STATE OF NORTH CAROLINA  
DEPARTMENT OF TRANSPORTATION

May 11, 2017

Subject: **Modification Request for Section 404 Nationwide Permit (NWP) 23 and Section 401 Water Quality Certification** for the widening of Kerr Avenue (SR 1175) from Randall Parkway to Martin Luther King, Jr. Parkway (SR 2649); TIP Project U-3338B; Federal Aid Project No. STP-1175(8), Debit \$570 from WBS No. 34932.1.1.

References: Section 404 NW 23 Action ID SAW-2003-01069 issued May 22, 2014  
Section 401 WQC Project No. 14-0350 issued May 12, 2014

PROJECT REFERENCE NO.	SHEET NO.
U-3338B	EC-79/CONST.41
RW SHEET NO.	
ROADWAY DESIGN ENGINEER	HYDRAULICS ENGINEER

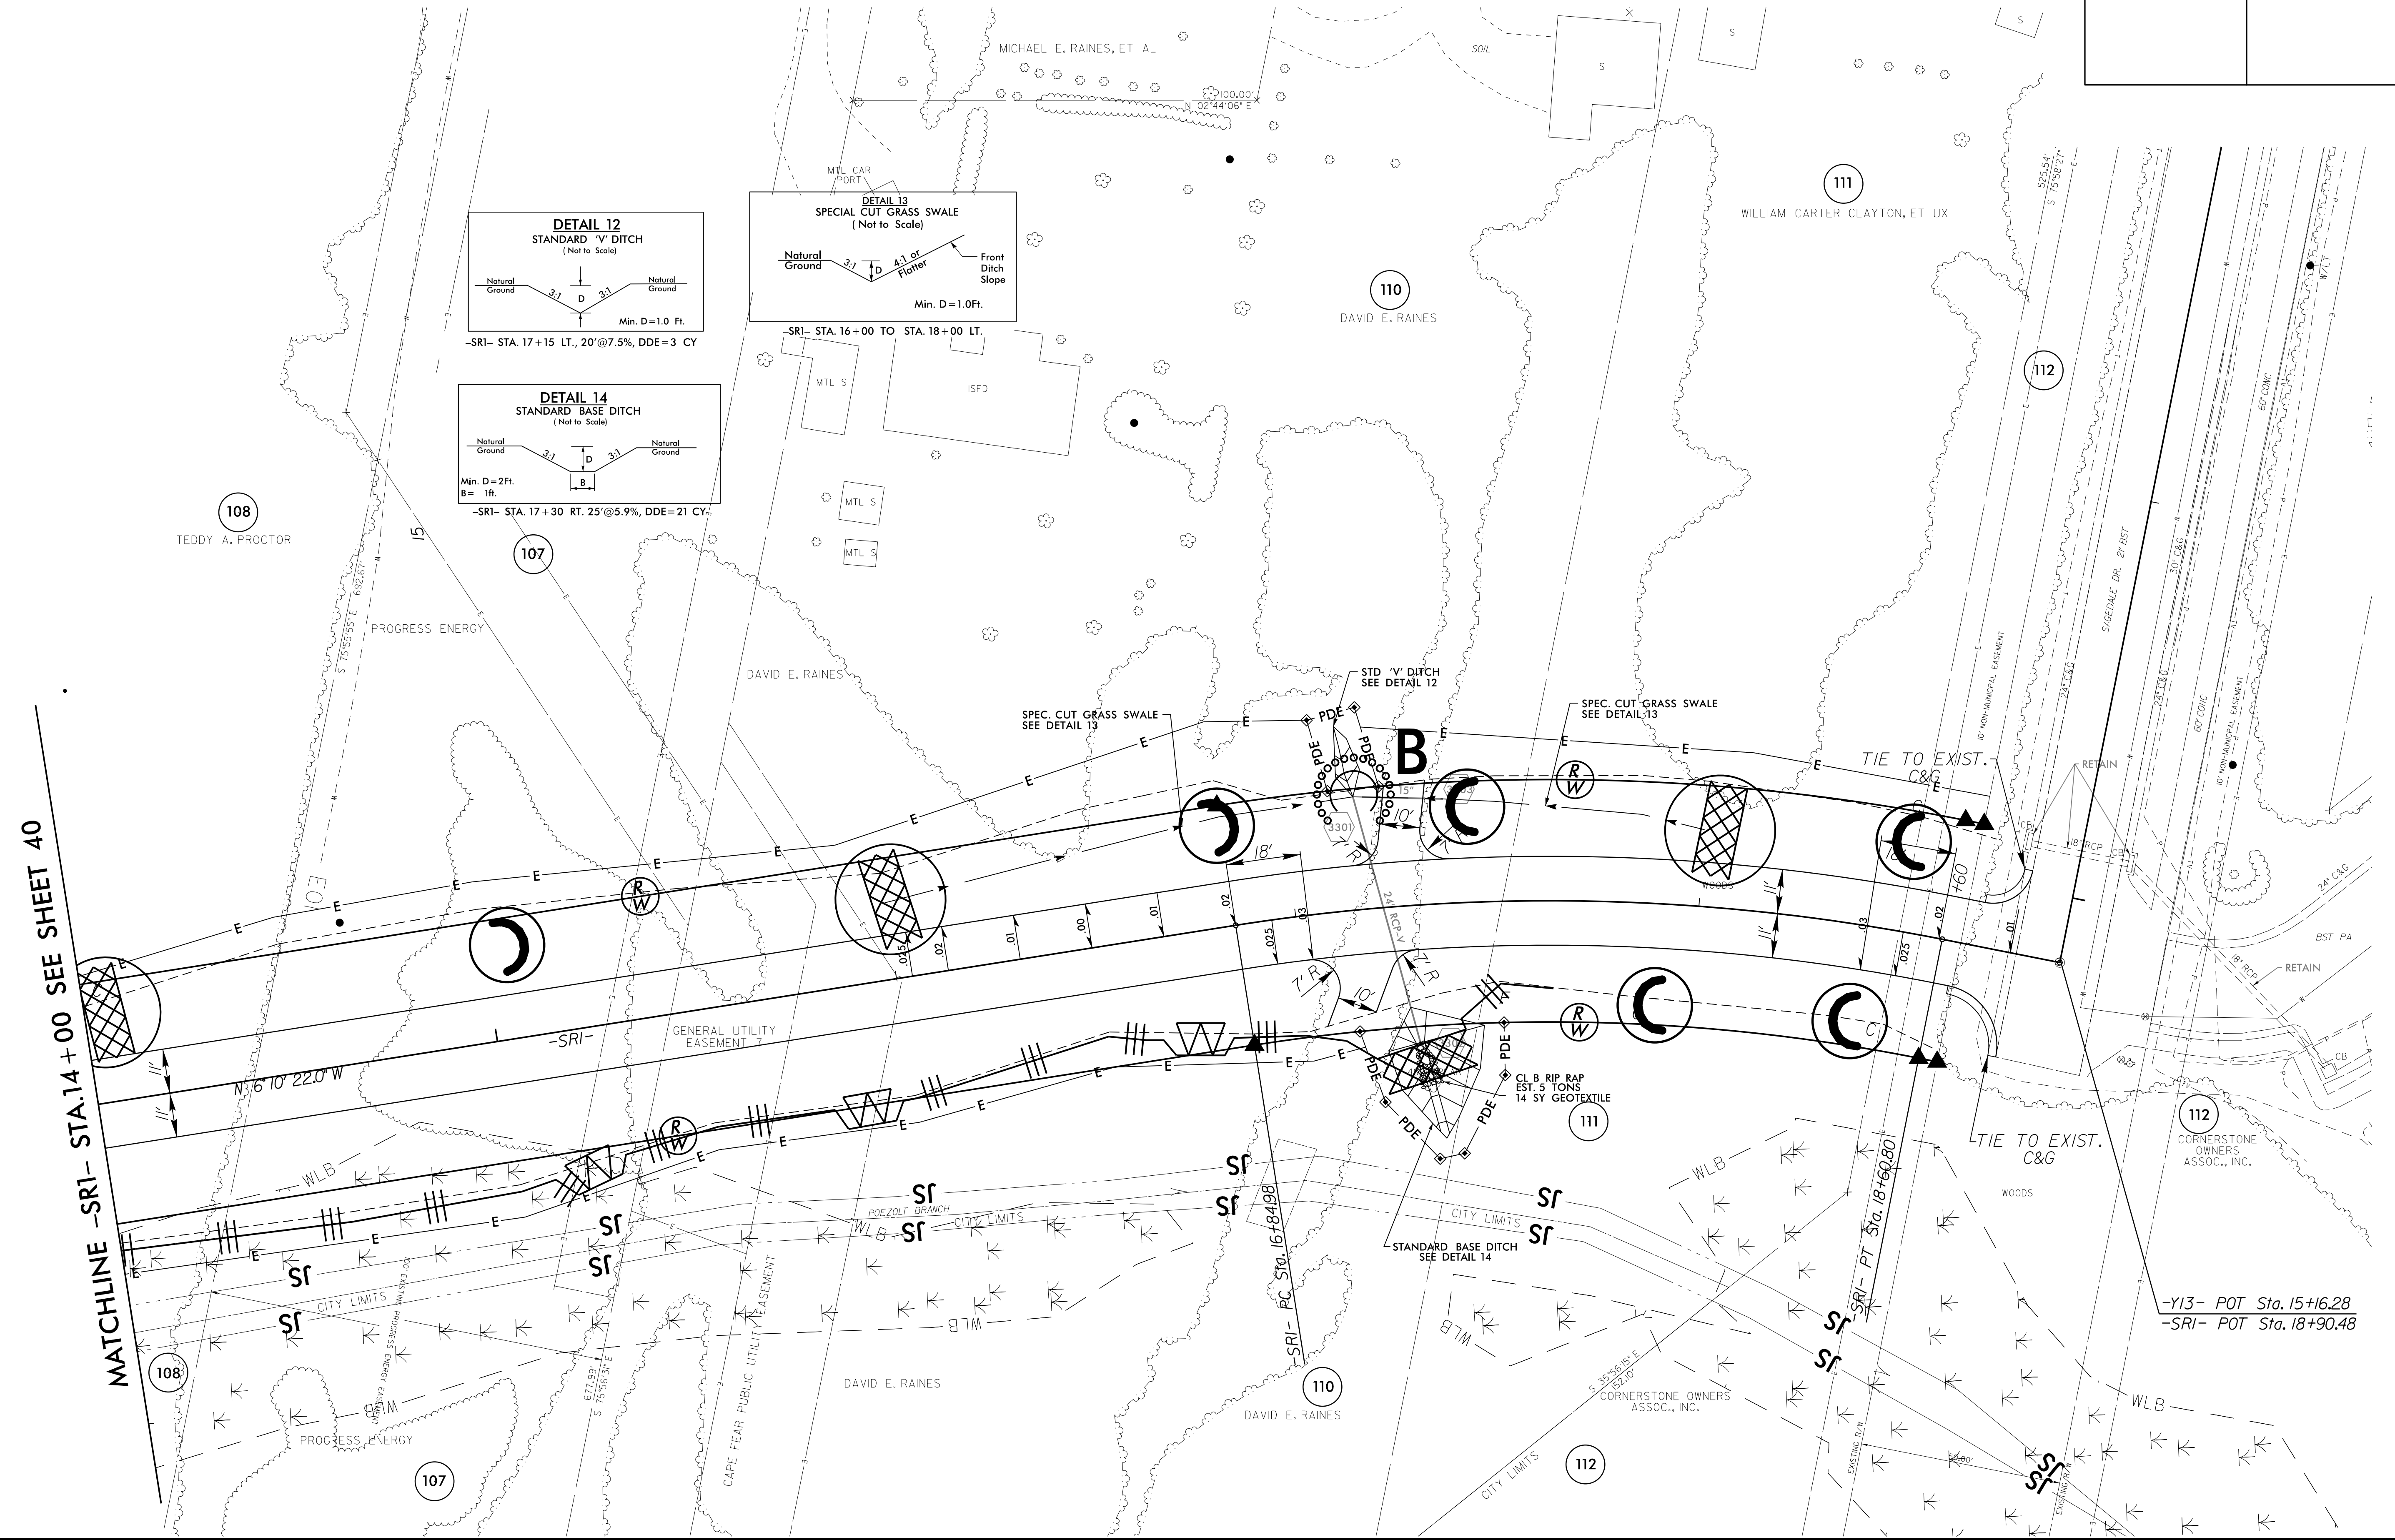
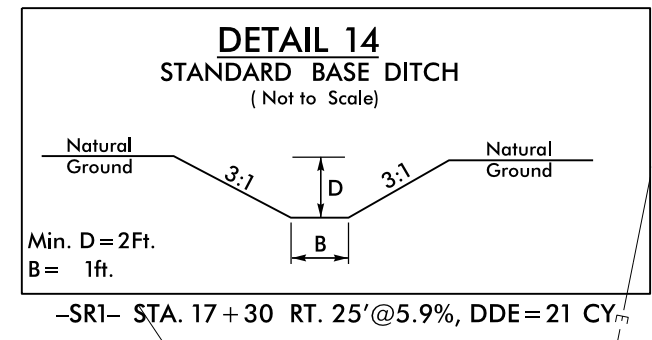
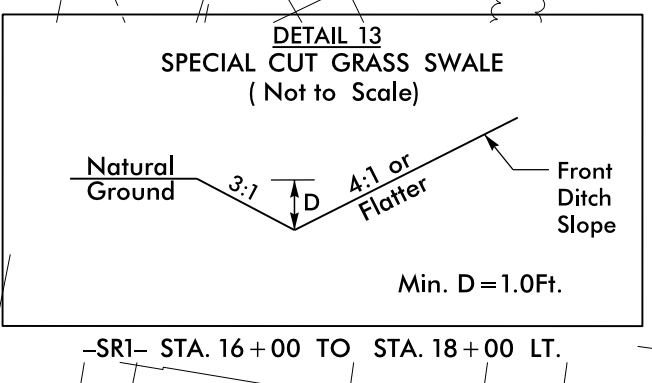
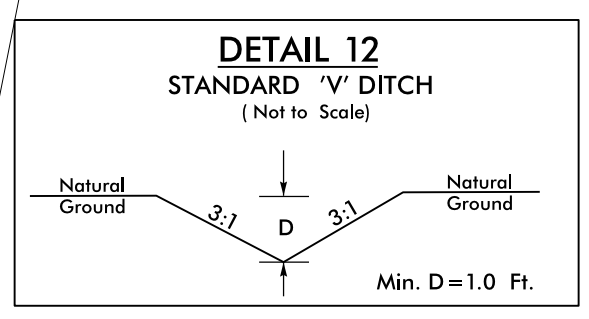
As you are aware, during clearing the contractor found a jurisdictional stream near the slope stake line for the alignment –SR1- (permit drawings 14 & 15) rather than running parallel and offset from it was shown in previously submitted permit drawings. The attached revised permit drawings show the stream in the proper location. Additionally, the Wetland Impact Summary Sheet has also been revised to account for the proposed additional stream and wetland impacts at Site 8.
